From: Simon Robinson [REDACTED]
Sent: 06 November 2019 14:40
To: Daun Johnson <Daun.Johnson@arun.gov.uk>
Subject: Re: Further Information Required on Your Ref: PP-08184574 Our Ref: BR/282/19/PL

Access Overview and Visibility Splays

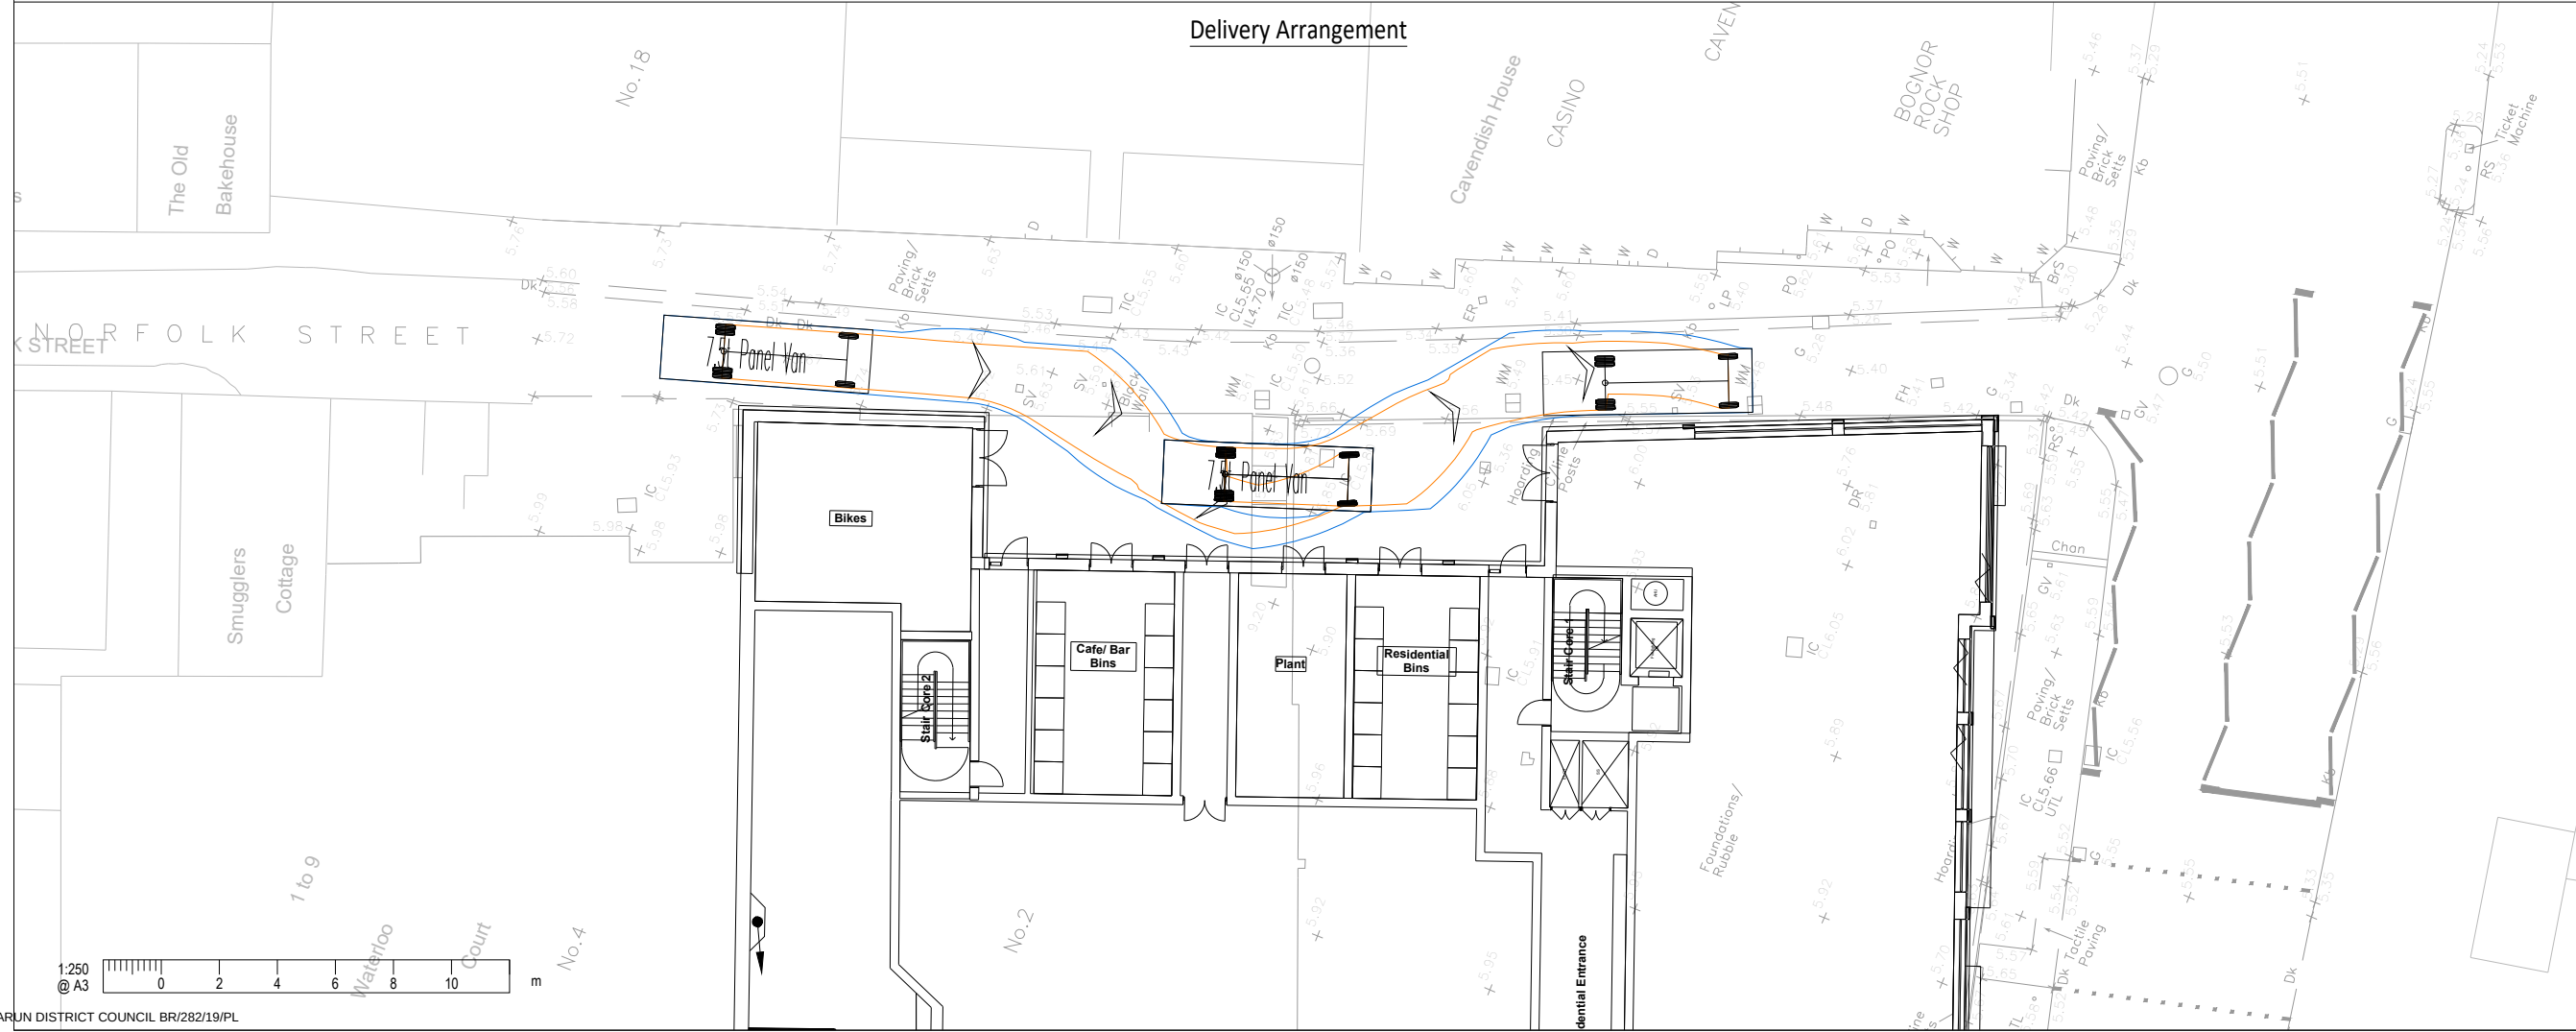
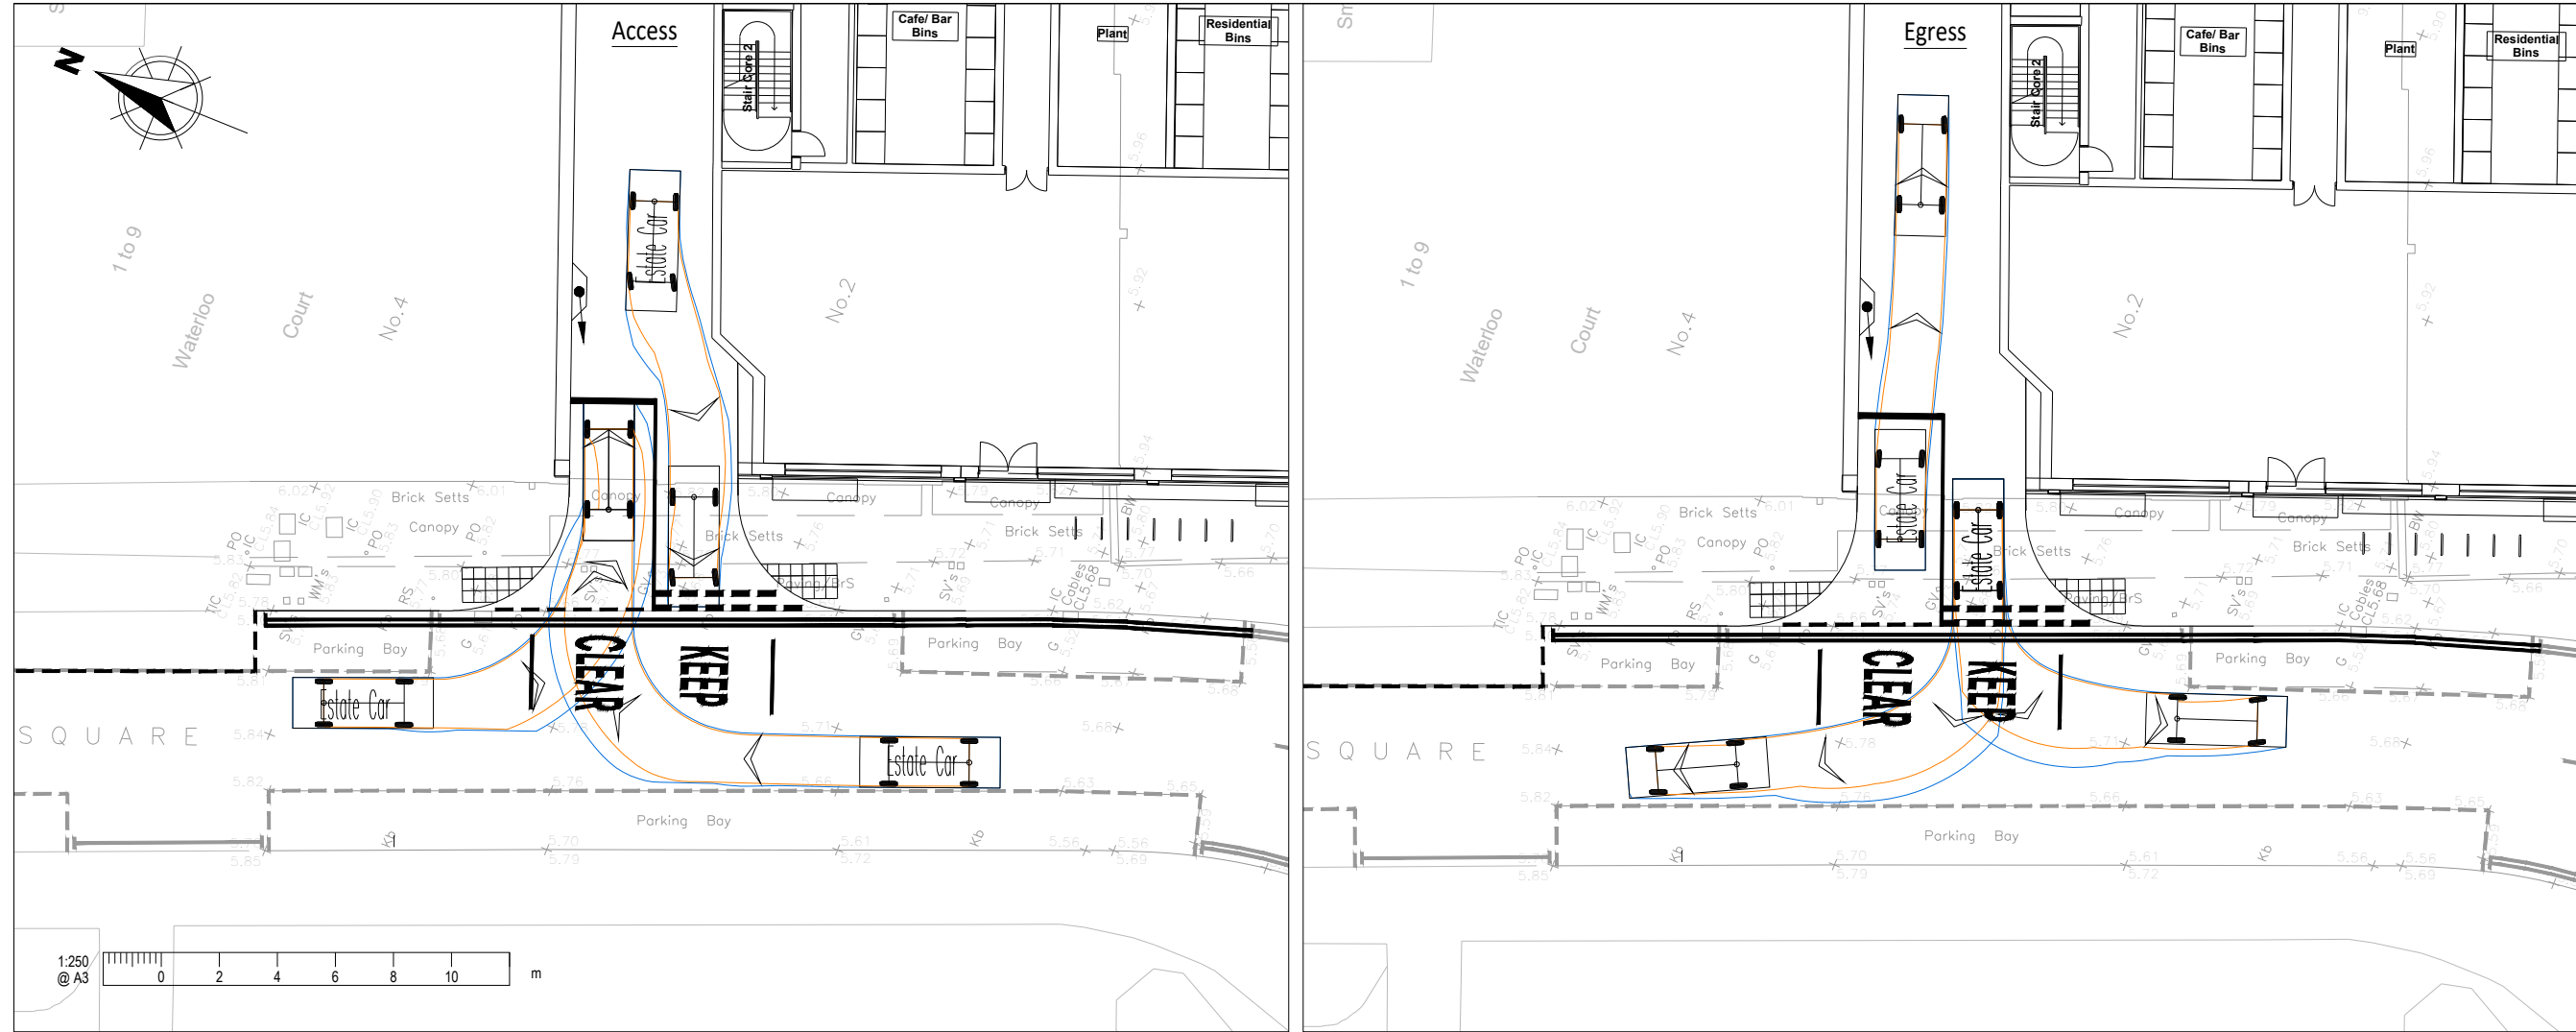
Item 2. Proposed Site Plan

We have prepared the site layout plans which include visibility splays, also sent in wetransfer link.
